**REQUEST**

Current Zoning: I-1 (Industrial)  
Proposed Zoning: MUDD-O (Mixed-Use Development District-Optional)

Approximately 0.48 acres located north of Freedom Drive, south of Thrift Road, and east of Berryhill Road.

The petition proposes to rezone the site to MUDD-O to adaptively reuse the site for residential and non-residential uses.

EXISTING/PROPOSED FREEDOM DRIVE CROSS-SECTION

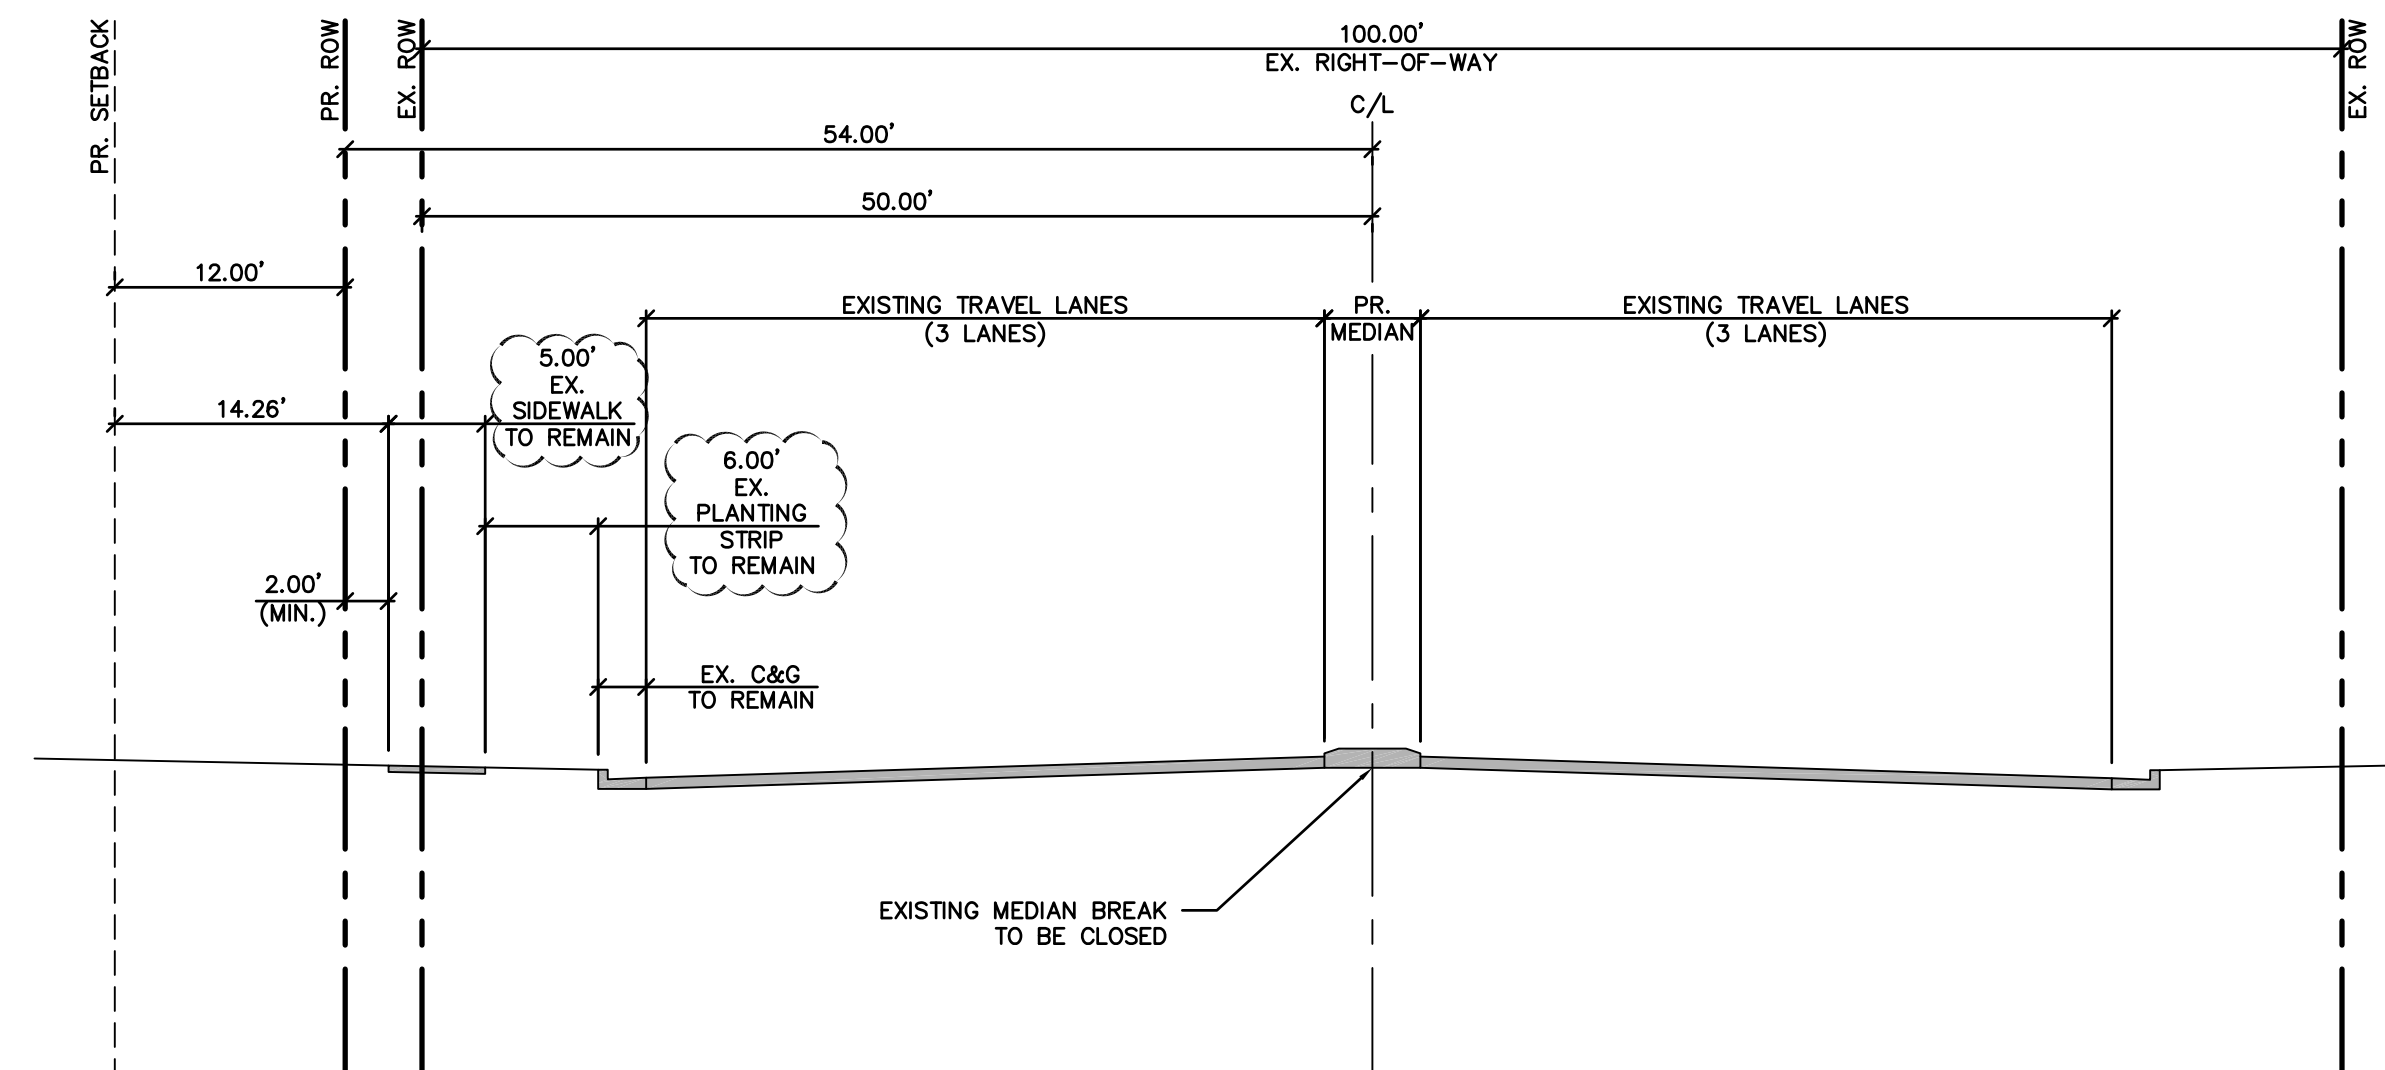
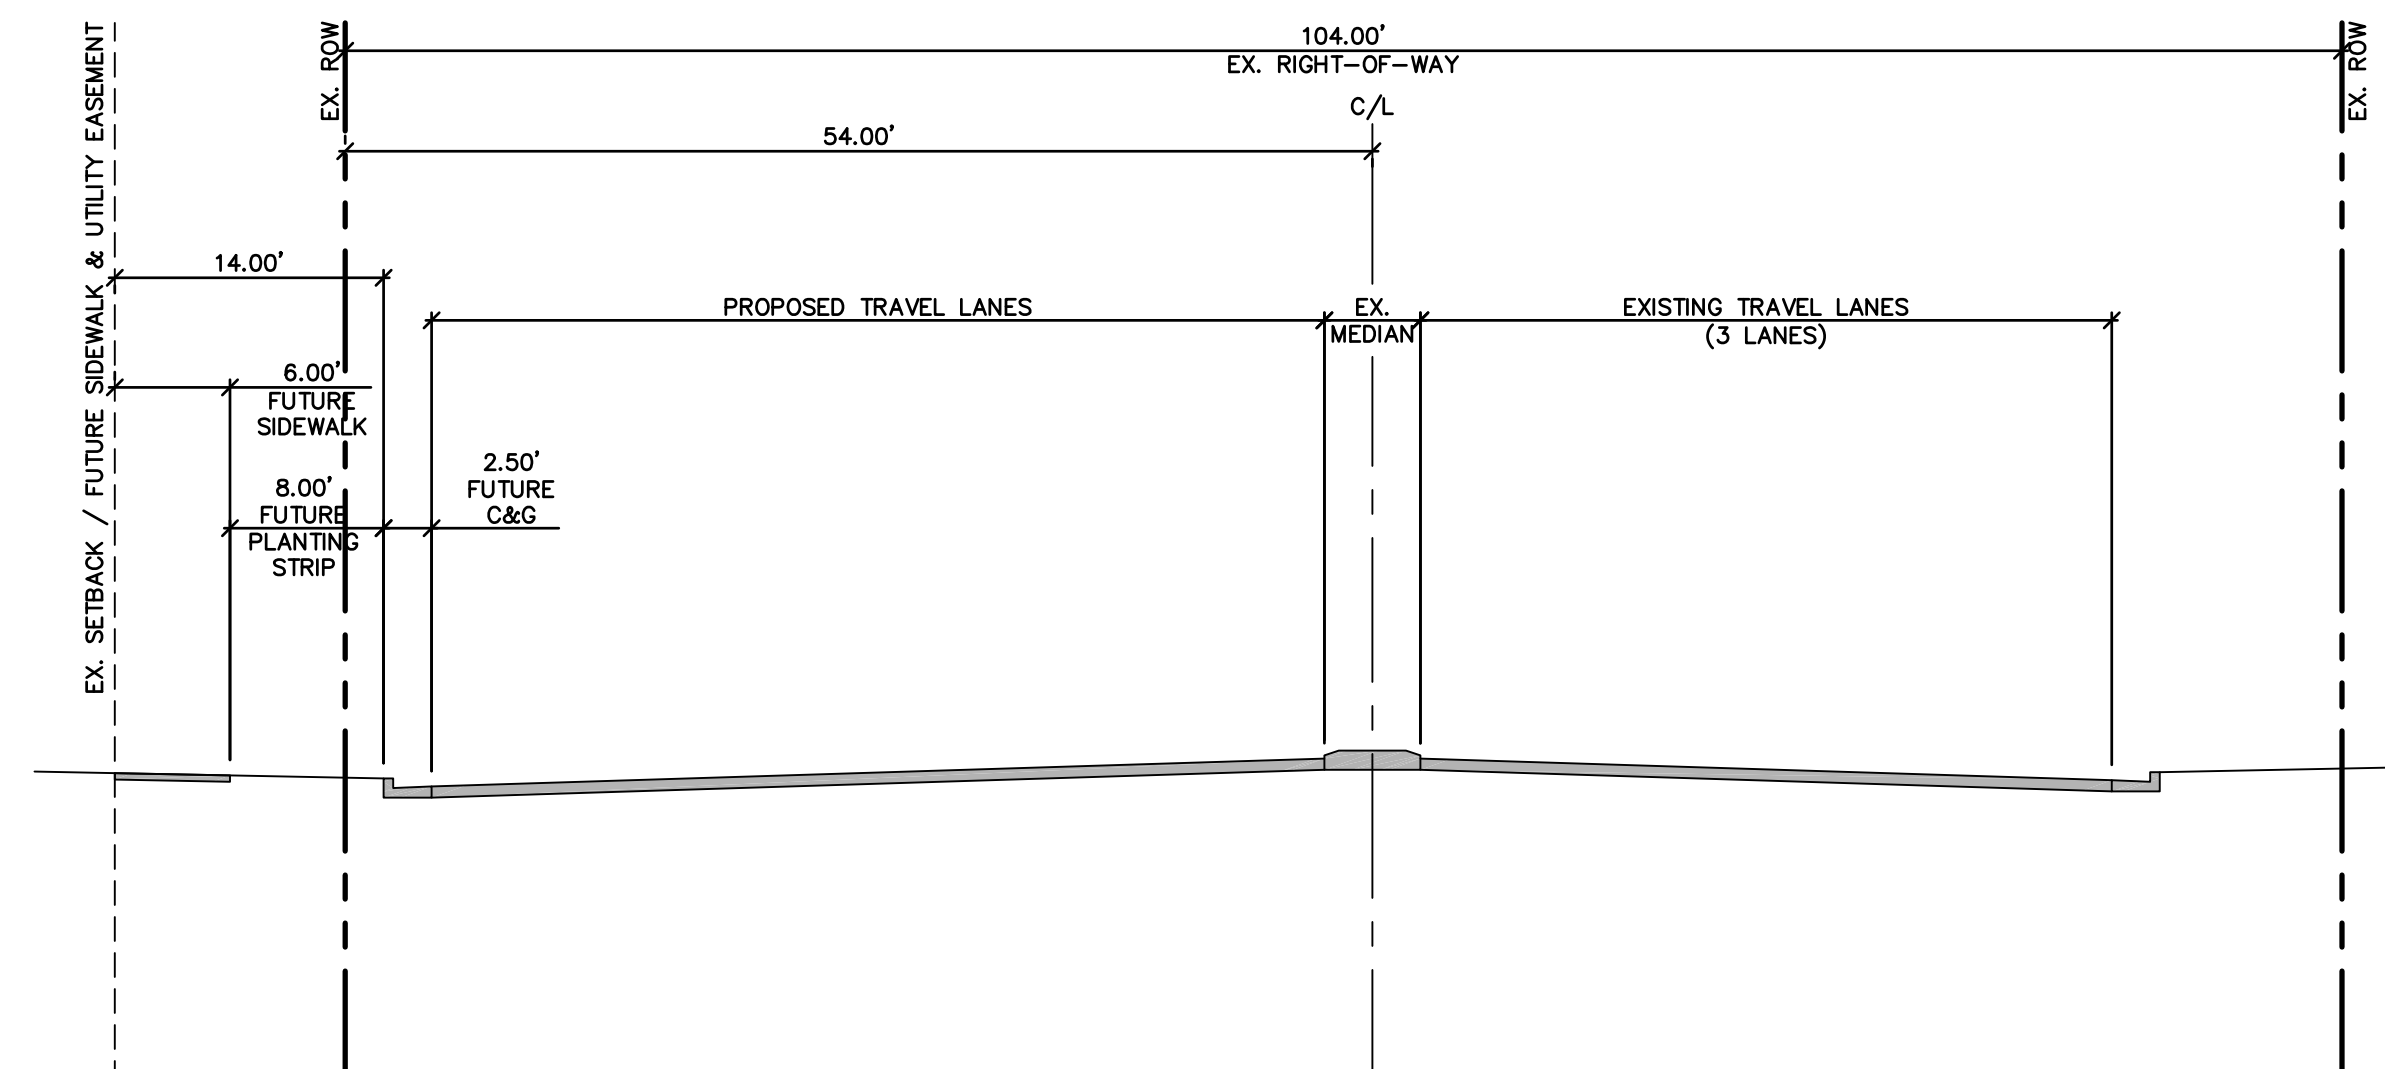
2. ~~On the development table, specify that the number of residential units and non-residential is the maximum.~~ **ADDRESSED**
3. ~~Add to note 2b that developer will work with CDOT and Urban Forestry staff during permitting on modifications to street-scape.~~ **ADDRESSED**
4. ~~Provide dimensions for existing sidewalk and planting strip on cross-section and in notes.~~ **ADDRESSED**
